Your Ref: 000013271
Our Ref: BR/150/12/ 30-05-2012
Please ask for:
Mrs S Leeson

Various landscape works. Demolition of wall to be re-built to 1.5m in height. Remove parking from frontage & create new car park to west side. New pavement to front of building, footpath & paved circle

University of Chichester Dome House Upper Bognor Road Bognor Regis

Thank you for your internet representation made on 24th July 2012 which has been recorded as **no objection** with the comments as follows:

Dome Building, University of Chichester
Wall Elevation

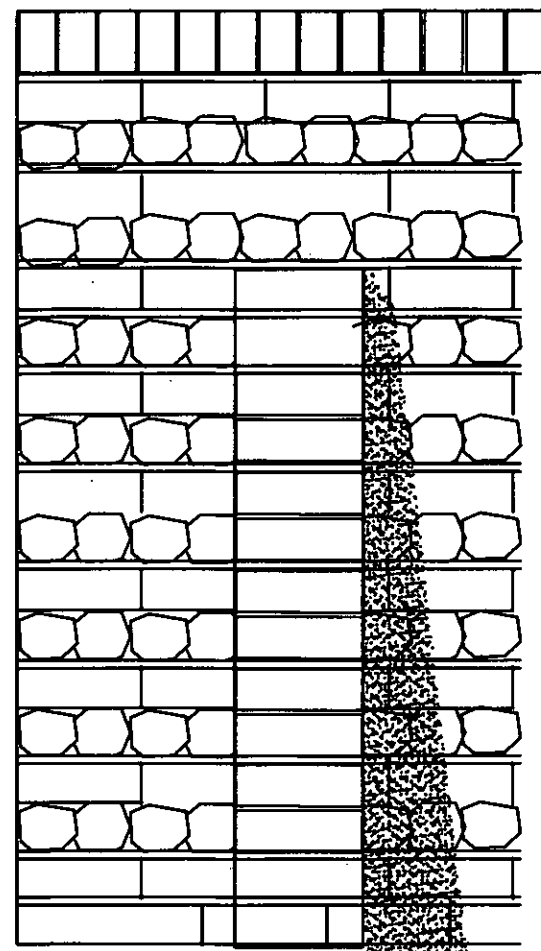
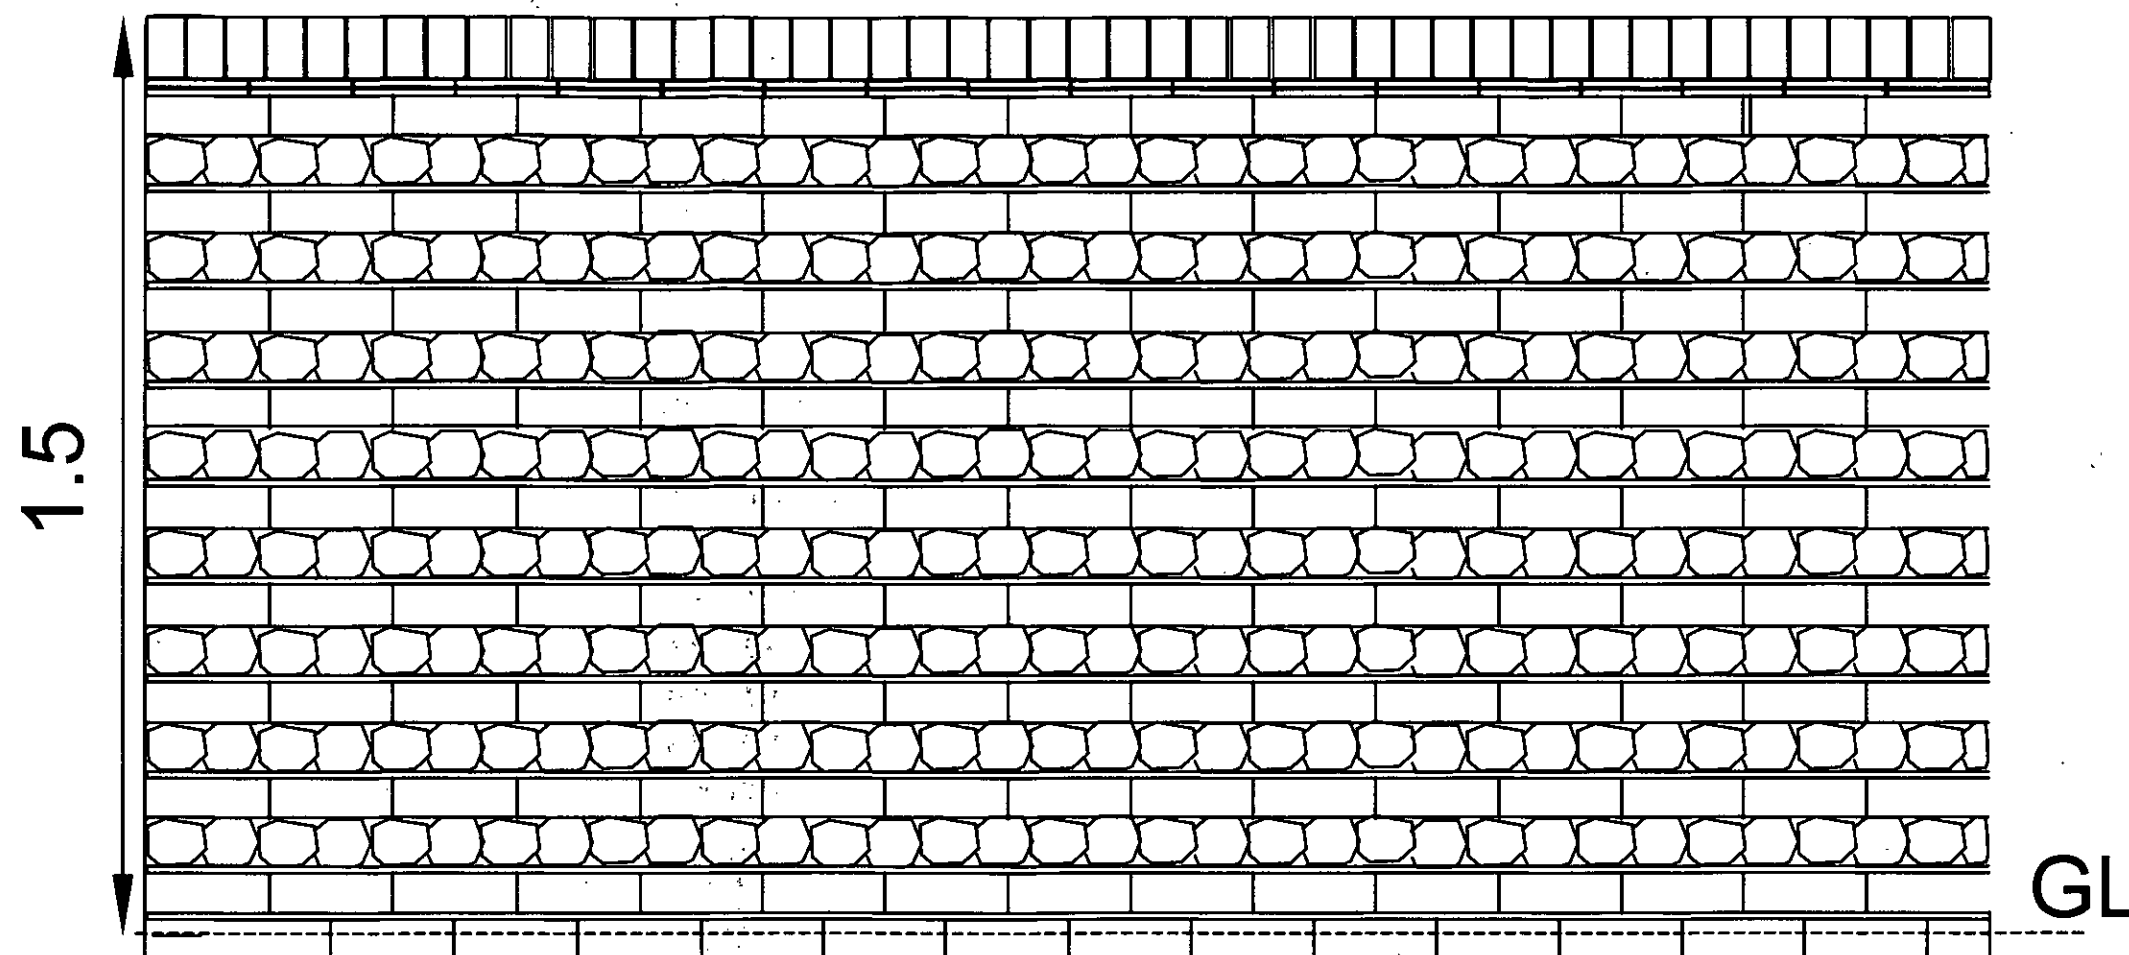
NO OBJECTION subject to the existing materials being used to re-build the wall
